MEMORANDUM

TO: Jean Fraser, Planner
FROM: David Senus, P.E. & Ashley Auger, E.I.T.
DATE: September 25, 2012
RE: Level I Site Plan Application – Baxter Blvd Storage Conduit Utility Building and Trail Work

Woodard & Curran has reviewed the Level I Site Alteration Application for a new utility building and trail improvement project along Baxter Boulevard in Portland, Maine. The utility building and trail improvement project are associated with a larger overall combined sewer overflow abatement project currently in design by the City, which proposes storage conduit within Baxter Boulevard. The City Department of Public Services has submitted an NRPA Permit application to the MaineDEP for the project.

SHEET # 11 **OF** #PGS
PLAN NUMBER

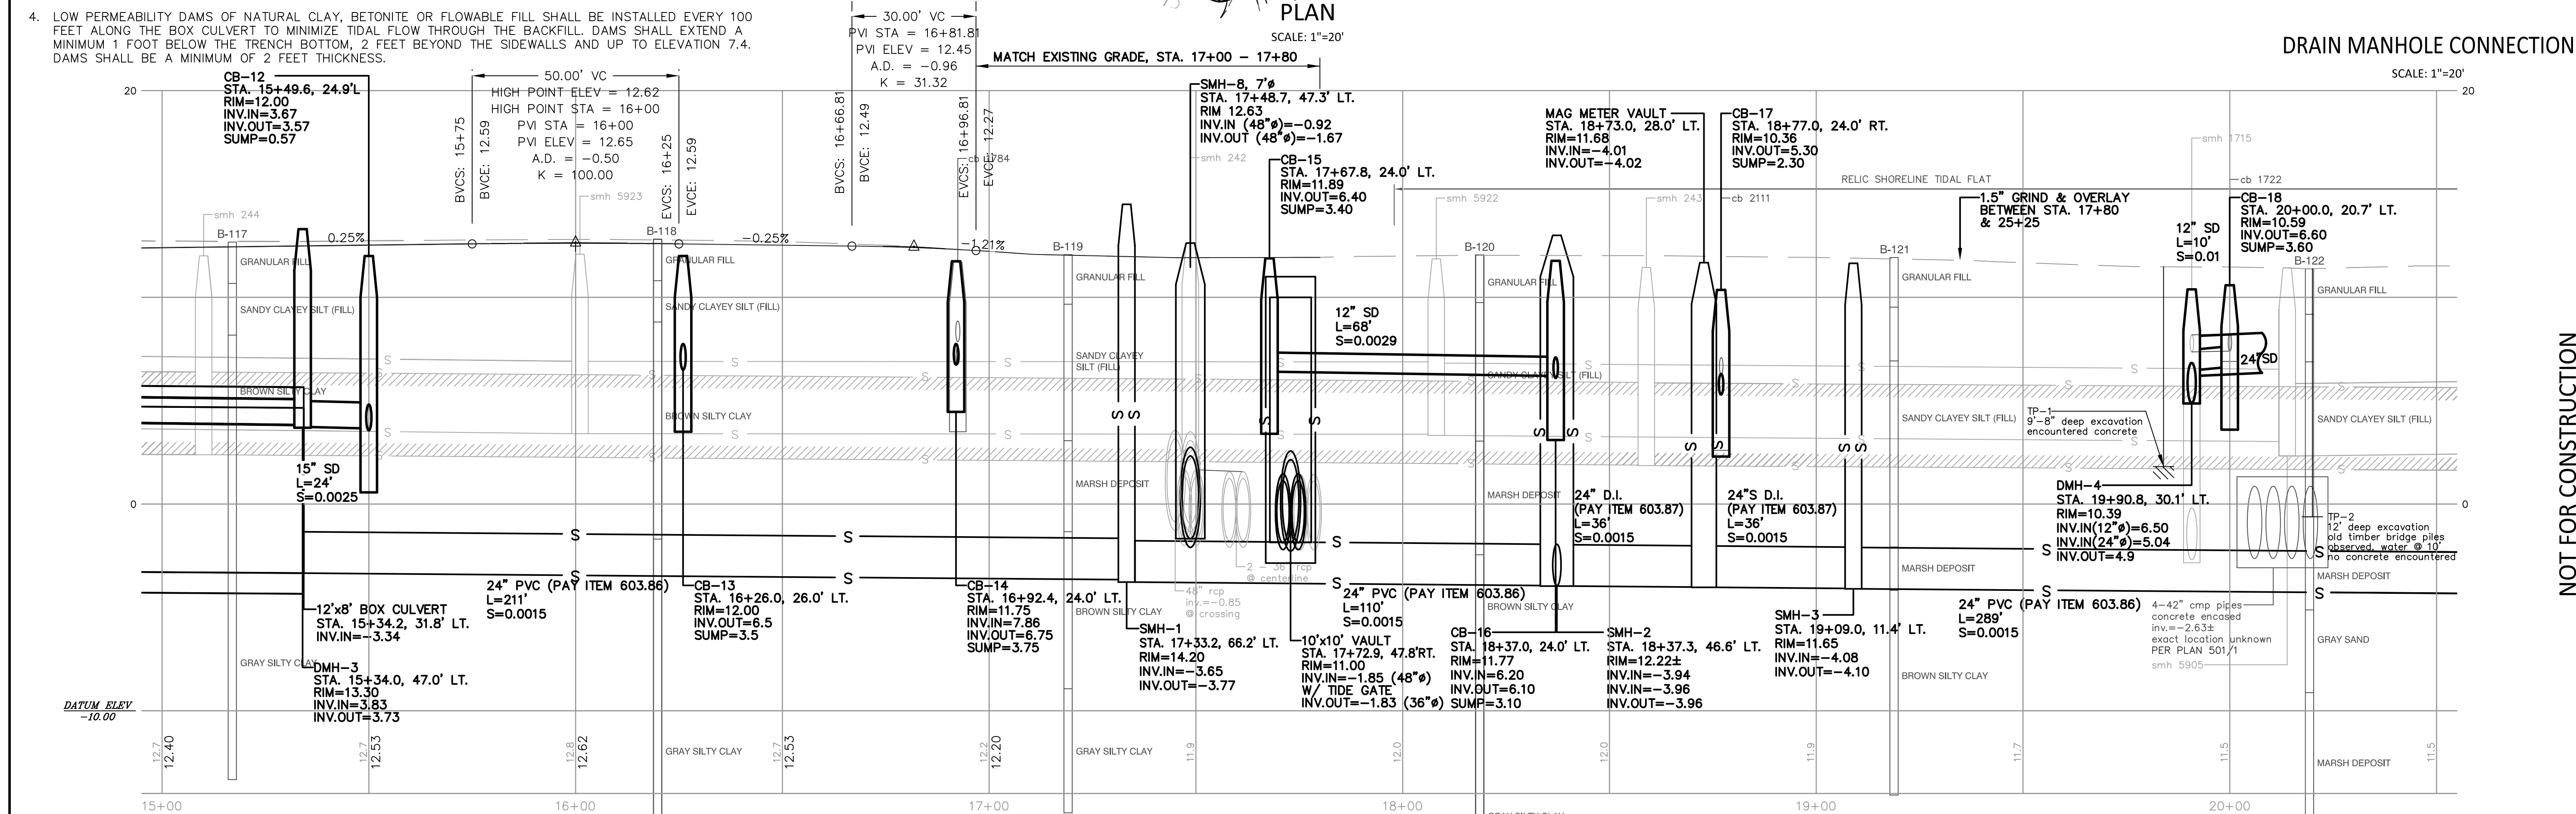
- 2) The Applicant should provide design details for the work (trail section, slope stabilization details, erosion control details).
- 3) A Level I Site Plan Submission is required to include proposed stormwater management controls and a soil erosion control plan (*City of Portland Land Use Code, Article V. Site Plan, Section 14-527(b) (12) and (13)*). Level 1 Site Alteration Plans are required to conform with certain site plan standards contained in the City Code of Ordinances, (*City of Portland Land Use Code, Article V. Site Plan, Section 14-526(b)3. – b,c,d*) specifically conformance with the Basic, General, Flooding, and Urban Impaired Stream standards
